From: Maria Tomalova
Sent: 19 June 2019 10:03
To: Planning.Responses
Subject: FW: FP/274/18/PL, 10 Felpham Gardens
Attachments: Prop GF Plan Unit 2 Rev B.pdf

From: Maria Tomalova [REDACTED]
Sent: 14 May 2019 12:47
To: Tim Rodway | Rodway Planning [REDACTED]
Subject: FP/274/18/PL, 10 Felpham Gardens

PROPOSED ELEVATIONS
UNIT 2

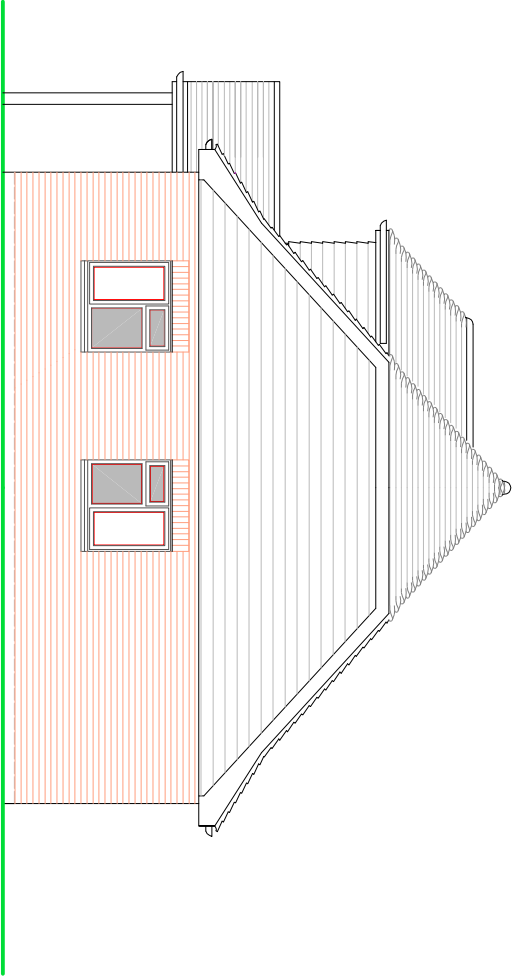
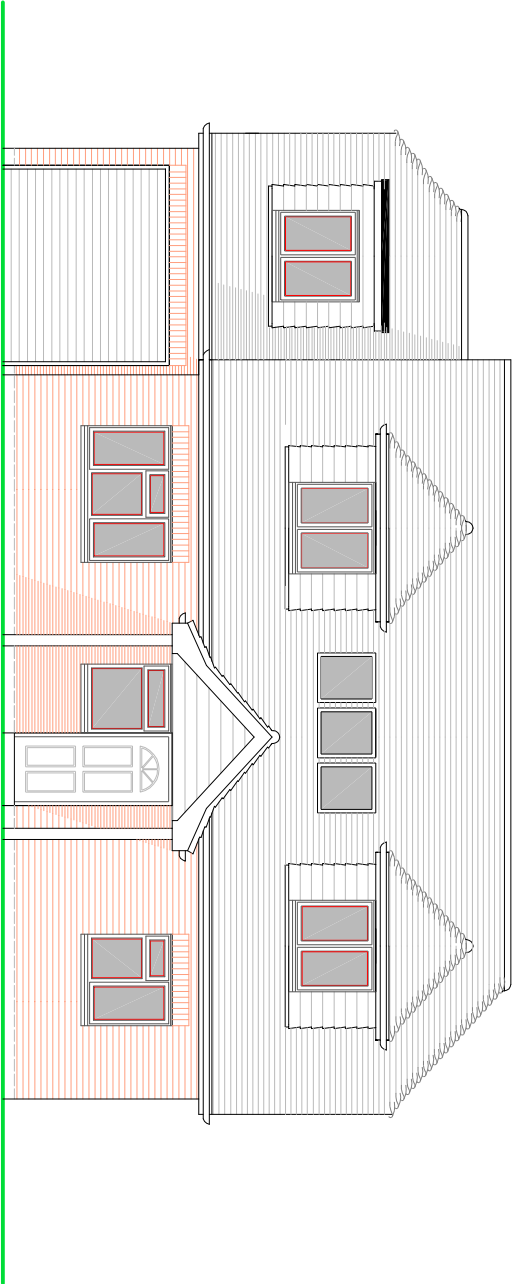
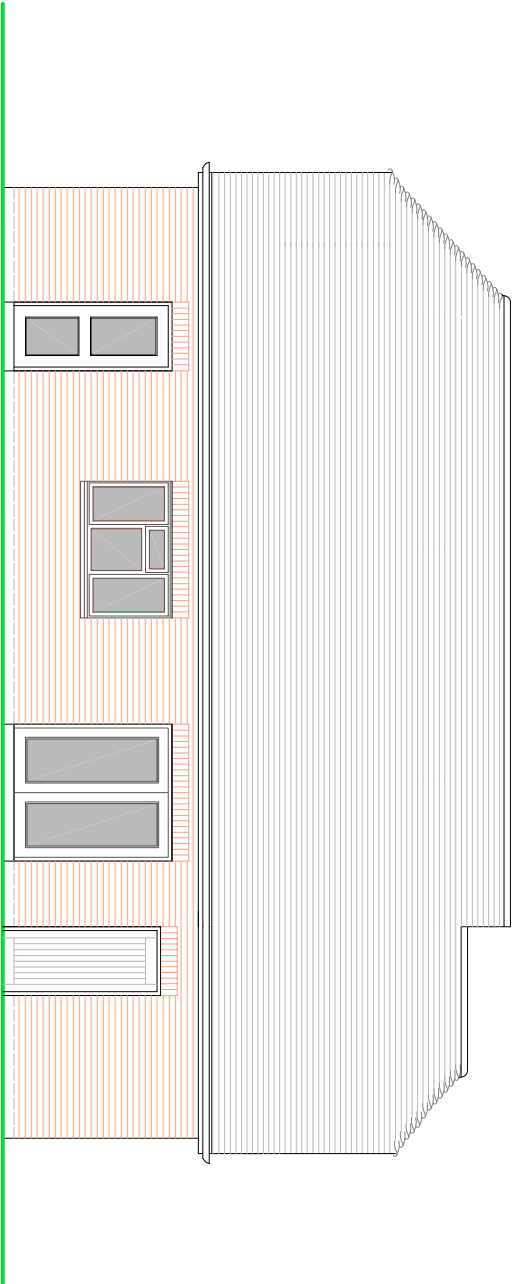
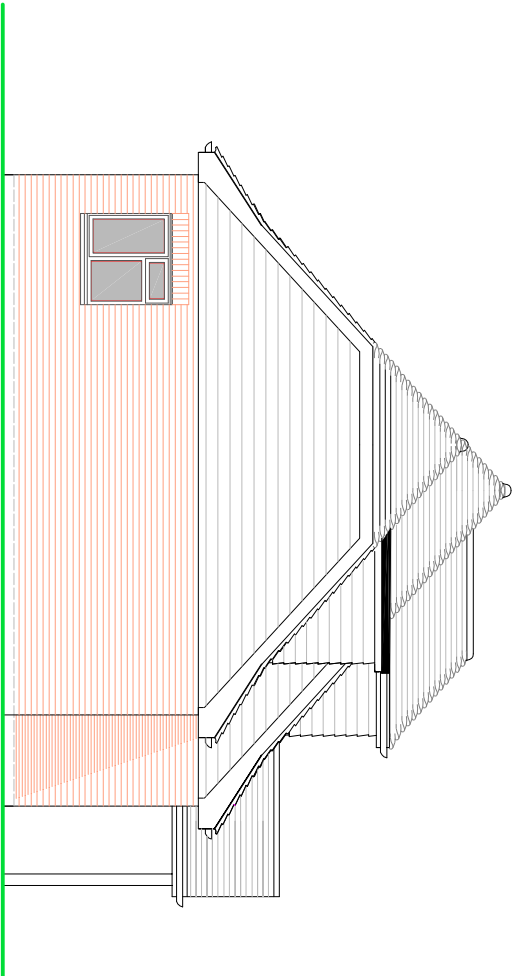
- Lower the ridge of the roof; one level in this particular case would be desirable
- Unit 1 is proposed aligned with the existing house No 8 Felpham Gardens as such it would not affect substantially the residential amenity of this property.
- However the proposed Unit 2 of the same shape and scale as Unit 1 would be obscuring the outlook from the rear of No 8 and would be an overbearing structure (12.5m deep, 6.7m high), entirely closing the view to the south and within the winter time when the sun is low, from the sun-light.
Suggestion: proposed Unit 2 should be reduced considerably (the height in the between of the proposed Unit 1 and an existing bungalows to the east) to be acceptable without affecting the amenity and prospect of inhabitants of No8
Probably you can reduce the width of Unit 2 by re-positioning the garage where the cycle storage is proposed with a direct access to it.

In summary, and in line with your advice, Unit 2 has been reduced to a single storey dwelling. Unit 2's garage has been repositioned, in line with your recommendations. We can advise that the gross internal floor area of the new bungalow is 84 m2, which comfortably meets the National Space Standards requirement for a 3-bed single storey dwelling.
